REQUEST

Current Zoning: N1-A (neighborhood one)
Proposed Zoning: R-8(CD) (single family residential, conditional)

Approximately 1.77 acres located on the south side of McKee Road, east of Weddington Road, and west of Savannah Hills Drive

The petition proposes to redevelop the existing single family home/lot with a total of 14 units, with two triplexes and two quadrplexes on individual lots for a site in southeast Charlotte.

REZONING
TECHNICAL
DATA SHEET

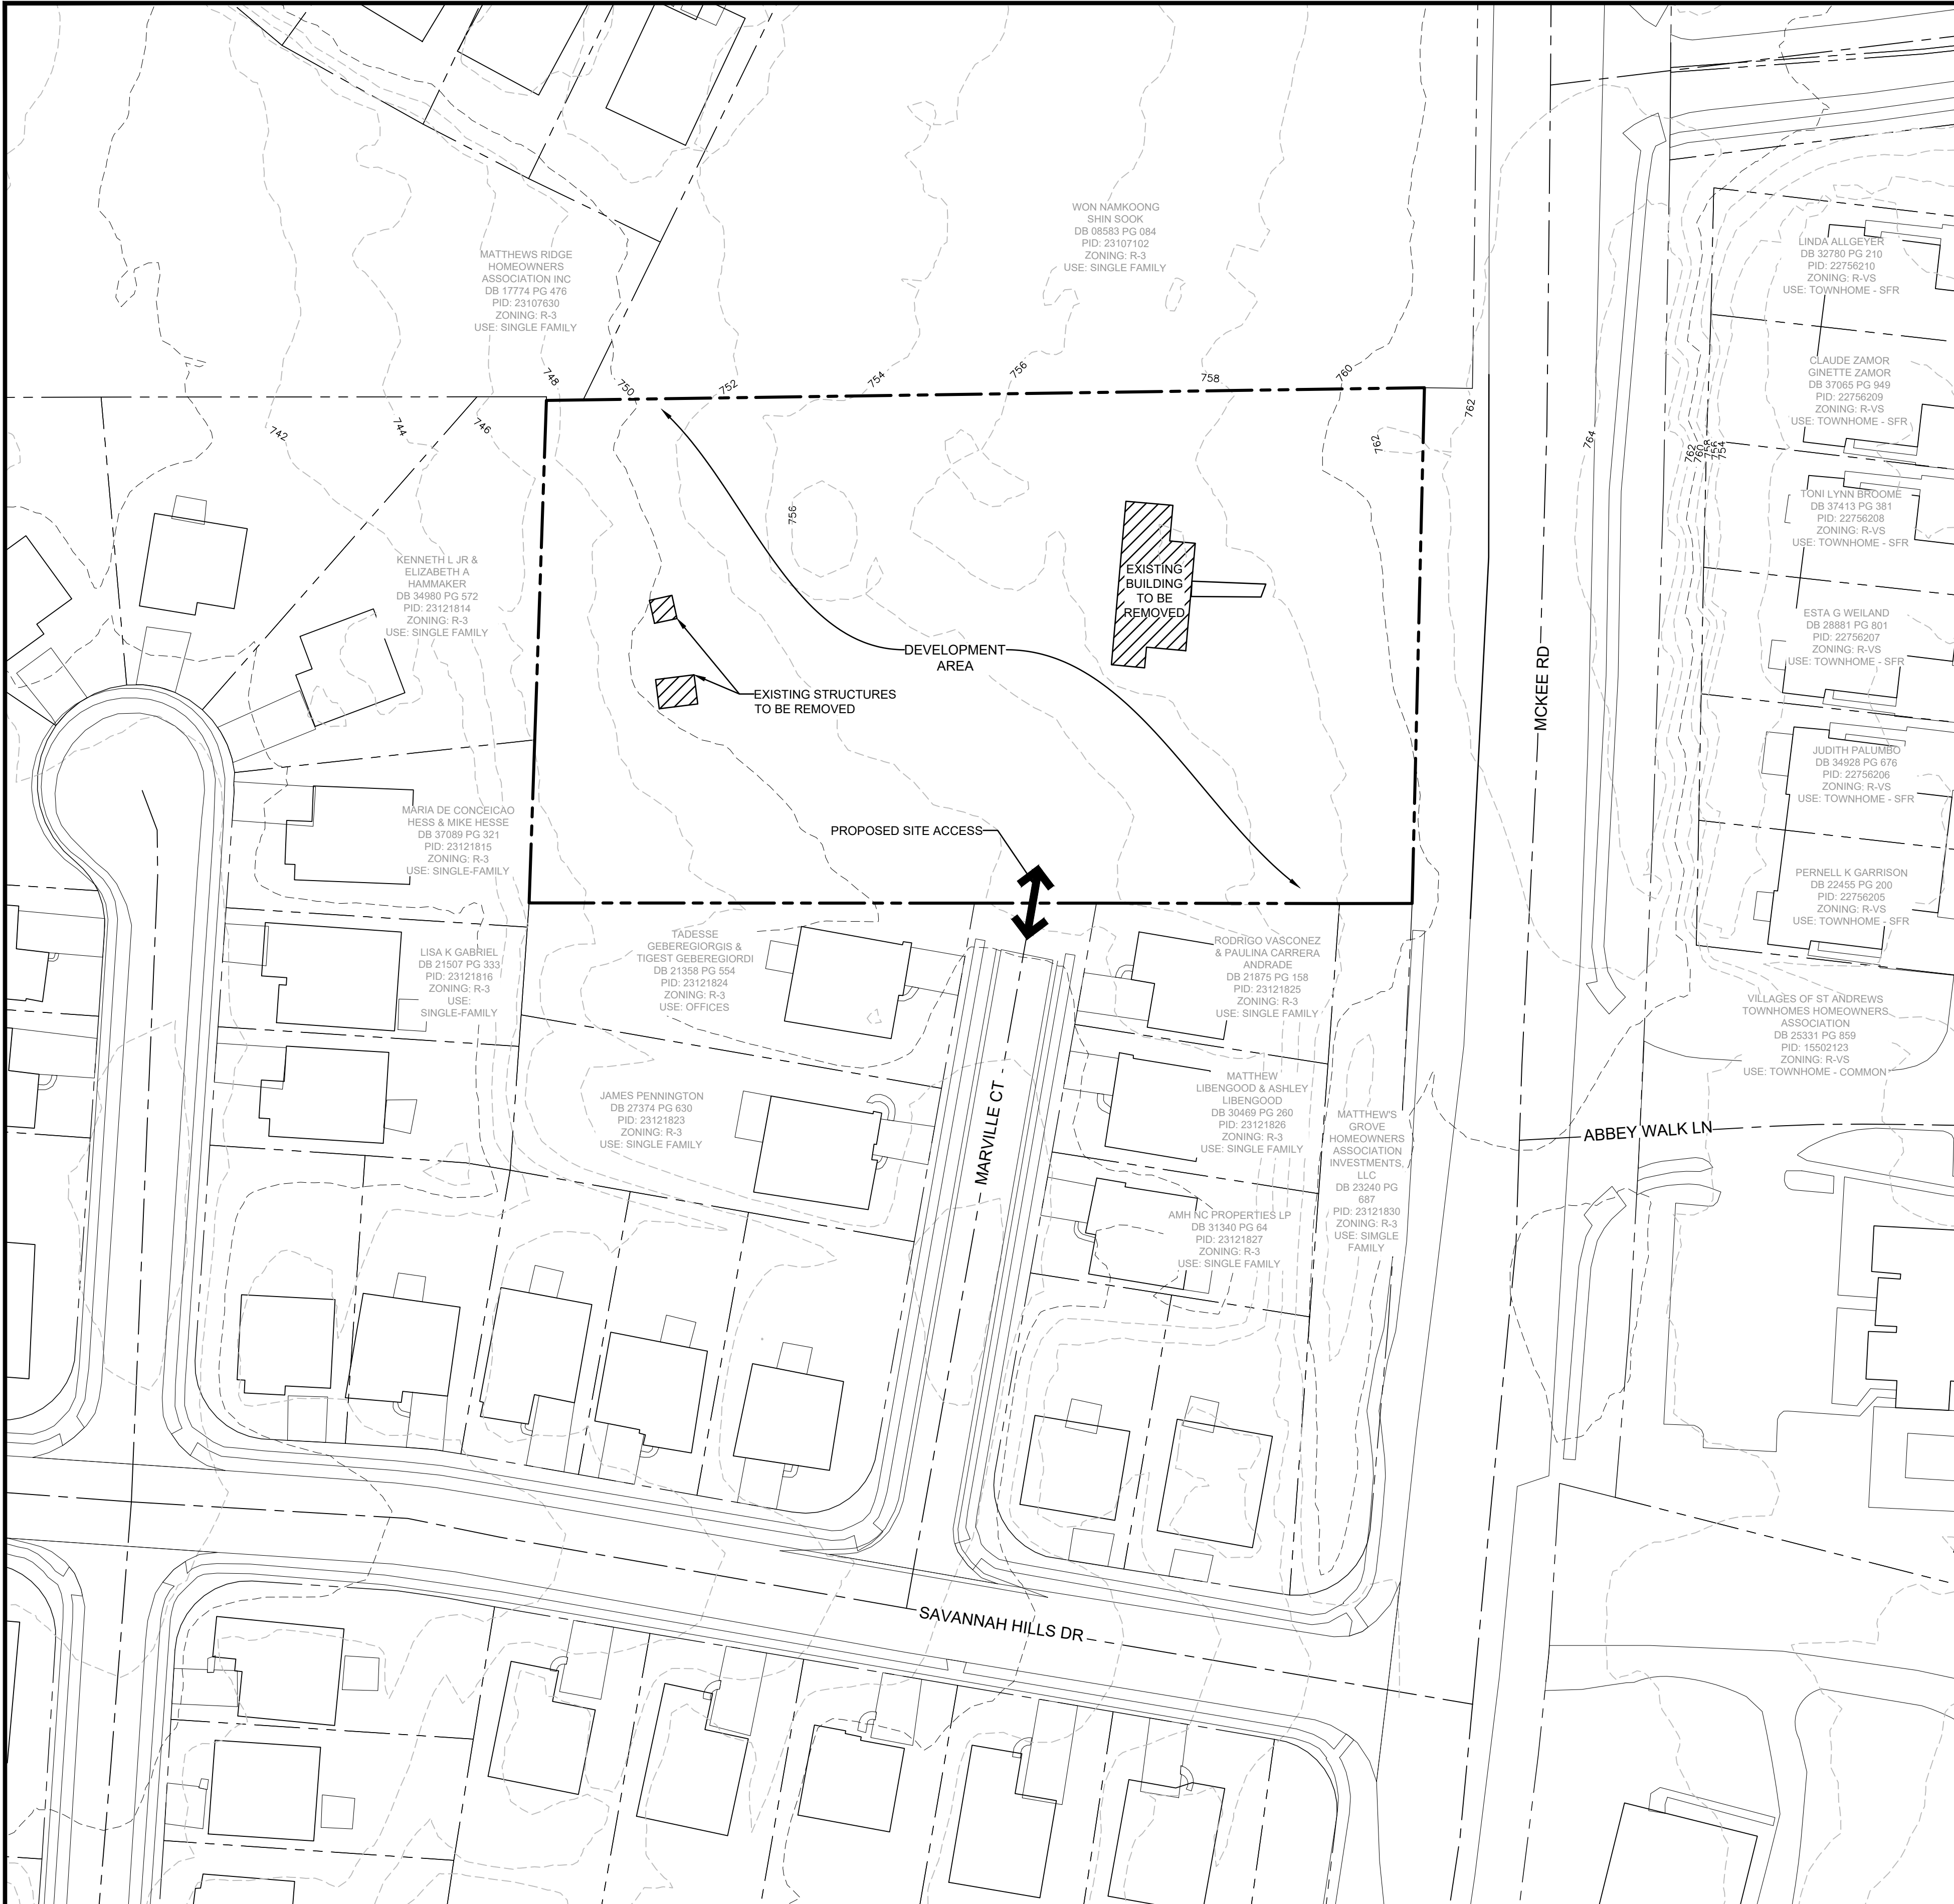
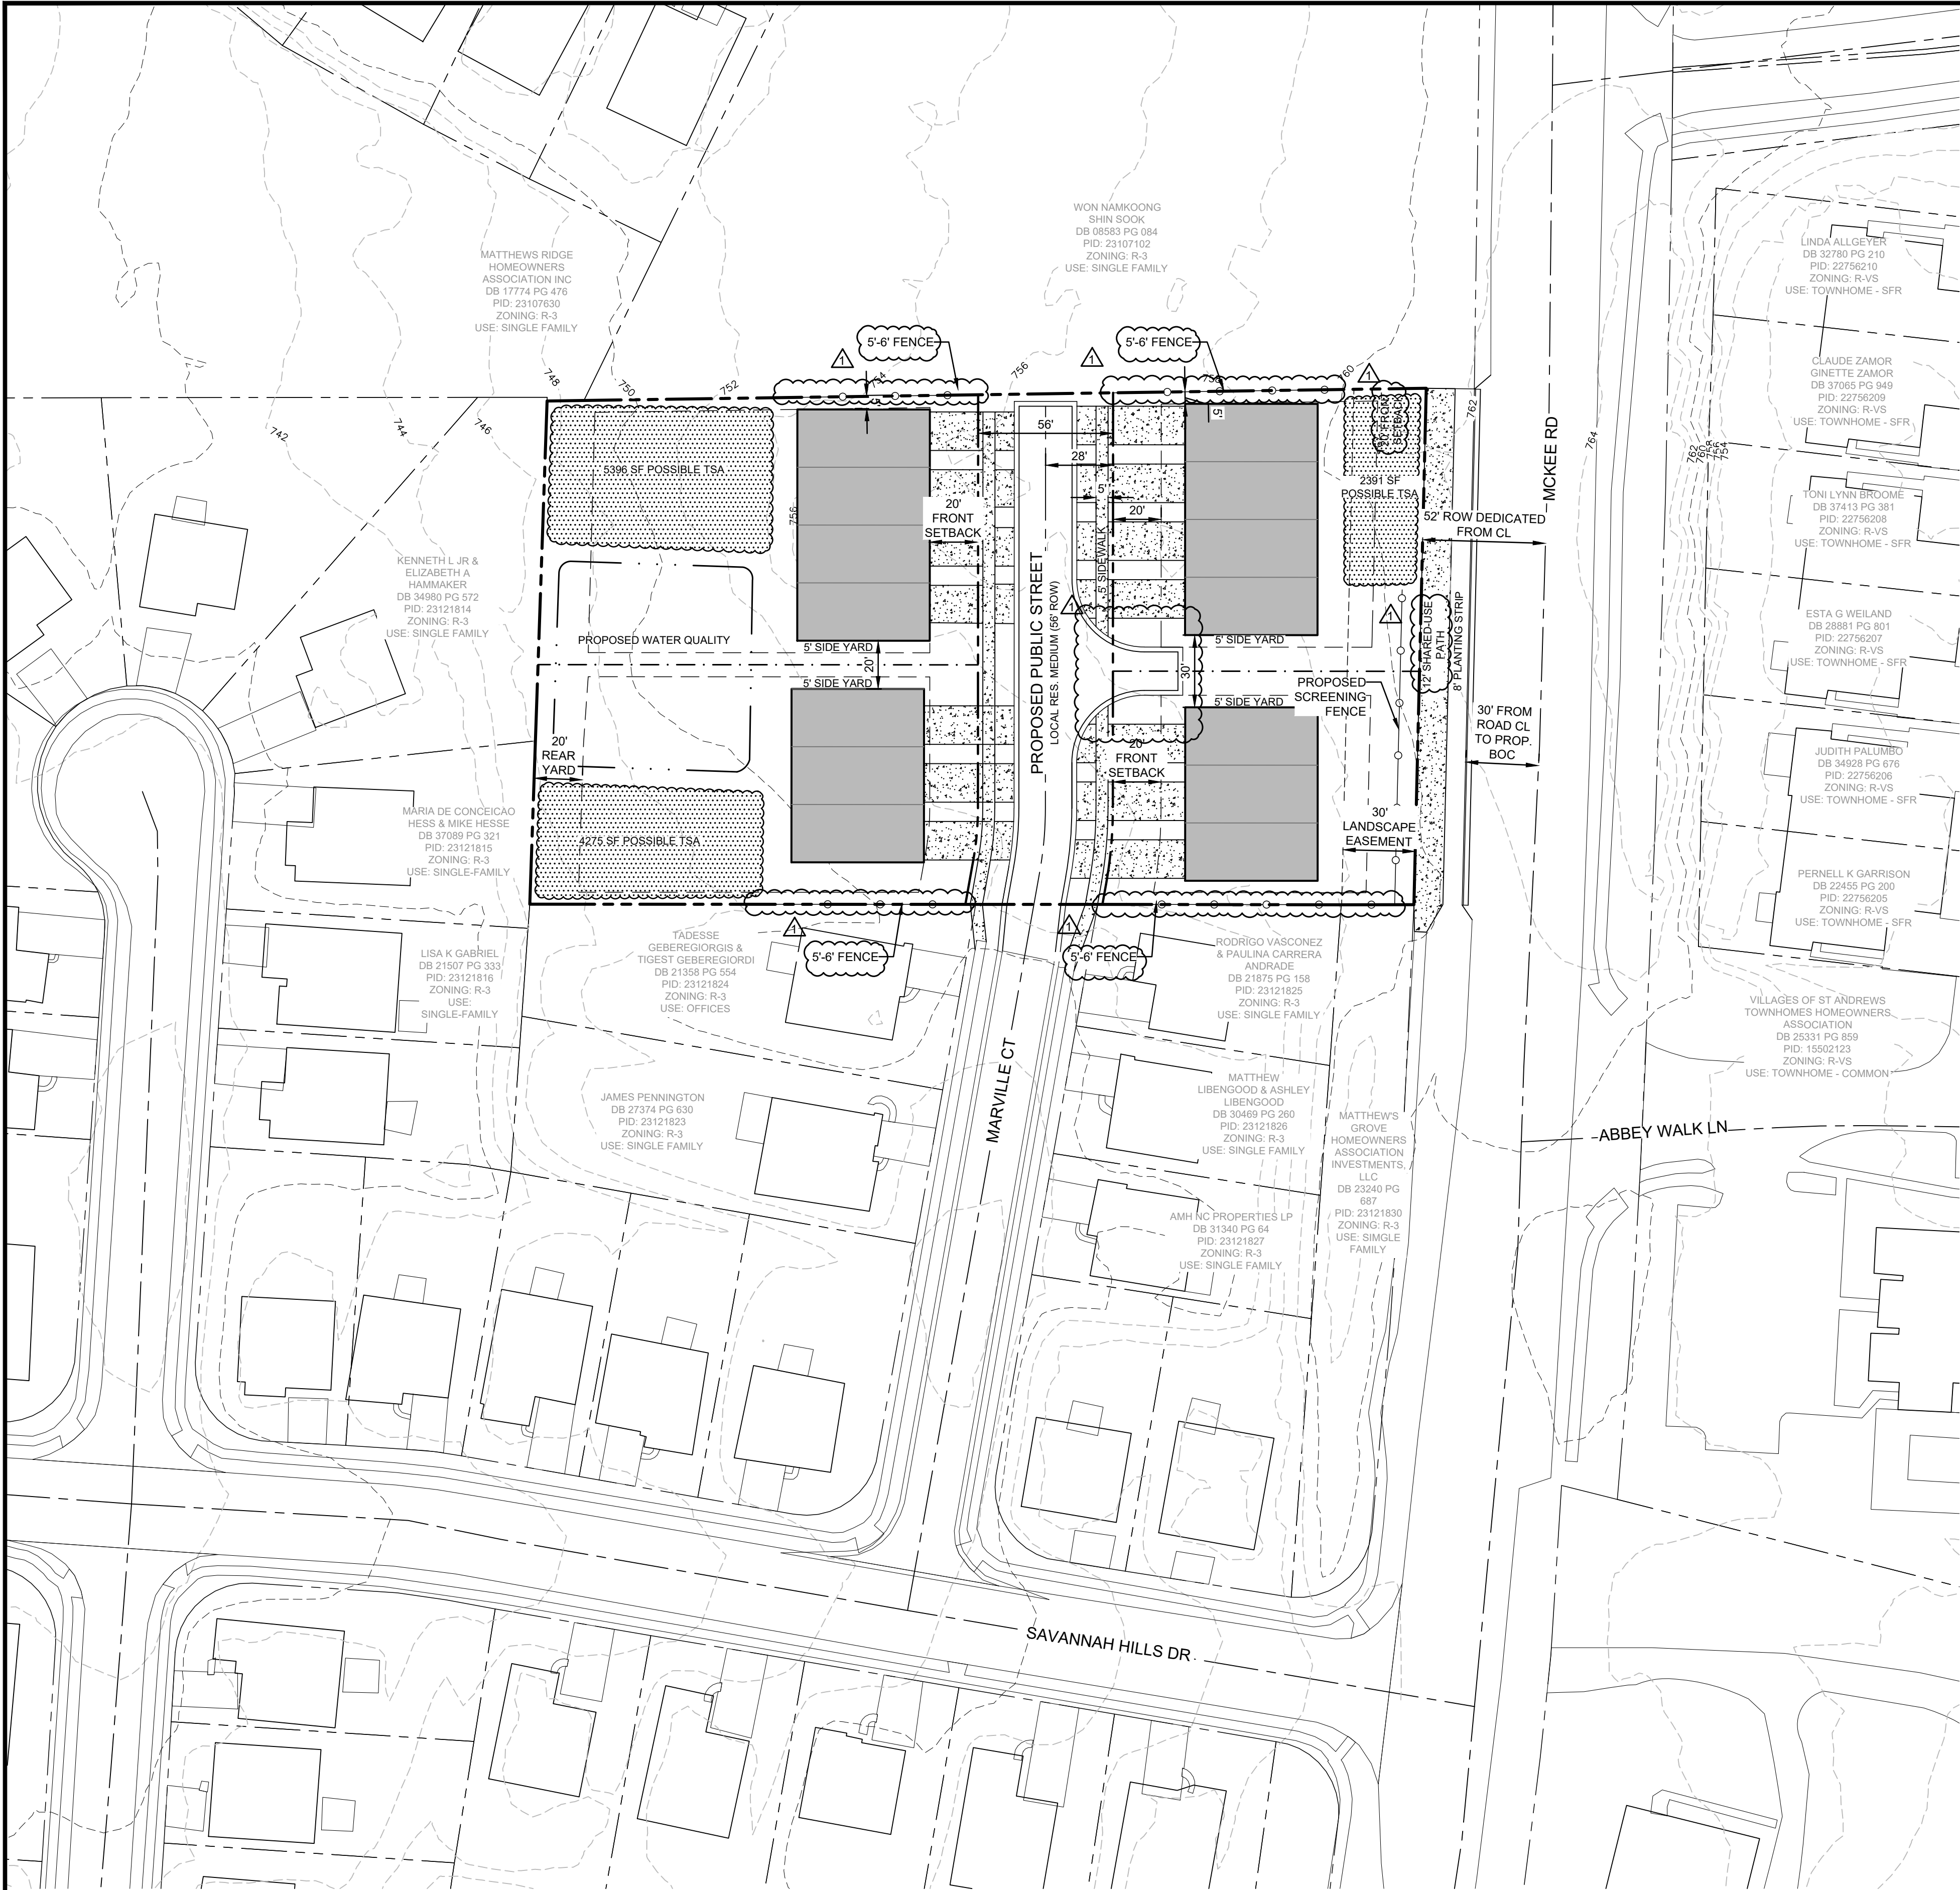
1. ~~Provide a note committing to the treatment of stormwater from including pre-existing impervious surface coverage.~~ Addressed
2. ~~Specify proposed stormwater conveyance from proposed water quality facility to existing stormwater infrastructure to minimize impacts to adjacent single family properties.~~ Addressed

3. ~~Refine Open space note 5.2 to clarify what is required, show desired tree preservation area on the site plan or provide a minimum width/buffer area of trees that should remain.~~ Addressed, note was deleted.

4. ~~Verify with Subdivision if 12.308 applies to this development. If so the 20 rear yard is measured from the inside edge of a 30 ft landscape area/common open space.~~ Addressed, 20 ft rear yard is required.

5. ~~Verify internal side yards shown on plan as they appear larger than 5 ft.~~ Addressed
6. ~~Correct inconsistency between the development data table and site plan for front setback. The data table says 30 ft setback from thoroughfare while the plan shows 20 ft. If 12.308 applies, then a 30 ft common open space or landscape easement is required, and a 20 ft rear yard is measured from there.~~ Addressed

7. ~~Show potential solid waste facilities on the site plan.~~ Addressed
8. ~~The legend includes proposed and existing trees, however none are depicted on the site plan. But note 5.2 references existing trees along the eastern property line.~~ Addressed
9. ~~Delete Architectural note 4.6 as it is repeated and 4.11 as is does not apply.~~ Addressed
10. ~~Update the existing zoning in the development data to reflect N1 A per UDO translation.~~ Addressed
11. ~~Add a commitment to provide pedestrian signage along Marville Ct.~~ Addressed
